REQUEST

Proposed Zoning: ML-2(CD) ANDO (Manufacturing & Logistics-2, Conditional, Airport Noise Disclosure Overlay), N1-A(CD) ANDO (Neighborhood 1-A, Conditional, Airport Noise Disclosure Overlay)

Approximately 7.59 acres located on the north side of Shopton Road, east of Steve Chapman Drive, and west of Pinecrest Drive.

RZ-1  
RZP-2024-064

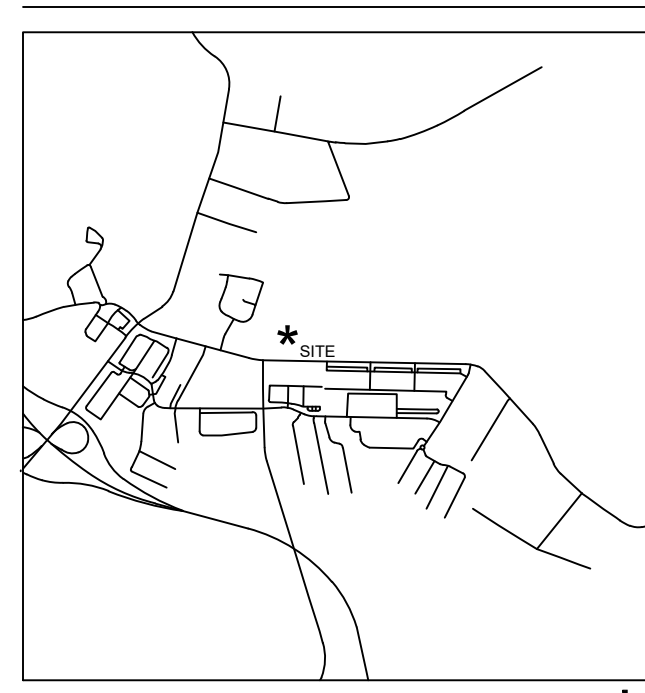
1. Reduce the maximum height to 40' to match adjacent I-2(CD) parcels to the east of the site.
2. Eliminate N1-A(CD) ANDO from the requested zoning. The entire site and all development standards associated with the proposed use should be under ML-2(CD) ANDO.
3. Extend the 65' Class A landscape yard to all areas adjacent to N1-A and CG zoning. Show the landscape yard across the septic field. A variance will be required following the rezoning process.
4. Revise the proposed use to limit only to contractor office with outdoor storage. Any other proposed use would require a subsequent rezoning.
5. Clearly illustrate the proposed outdoor storage yard area on the site plan.

6. Add standard Stormwater note "The petitioner shall comply with the Charlotte City Council approved and adopted Unified Development Ordinance, Stormwater Articles 23 through 28. The location, size, and type of storm water management systems that may be depicted on the Rezoning Plan are subject to review and approval as part of the full development plan submittal and are not implicitly approved with this rezoning. Adjustments may be necessary in order to accommodate actual storm water treatment requirements and natural site discharge points."

7. Remove note 8.B referencing proposed PCSO treatment areas.
8. City of Charlotte GIS data indicates a 30-ft PCSO buffer across the site. Please show and label Potential 30-ft PCSO Buffer on the site plan. Any increase of impervious area within such buffers may not be allowed and is not approved with the rezoning process. Stream Delineation Reports are subject to review and approval by Charlotte Storm Water Services. --- Please include the following note under Environmental Features: "Development within any SWIM/PCSO Buffer shall be coordinated with and subject to approval by Charlotte-Mecklenburg Storm Water Services and mitigated if required by City ordinance."

9. Provide a tree survey identifying all city trees 8" DBH or greater and all planted city trees, all existing heritage trees, and any existing areas of the site used for credit toward meeting previously approved tree save or green area requirements.
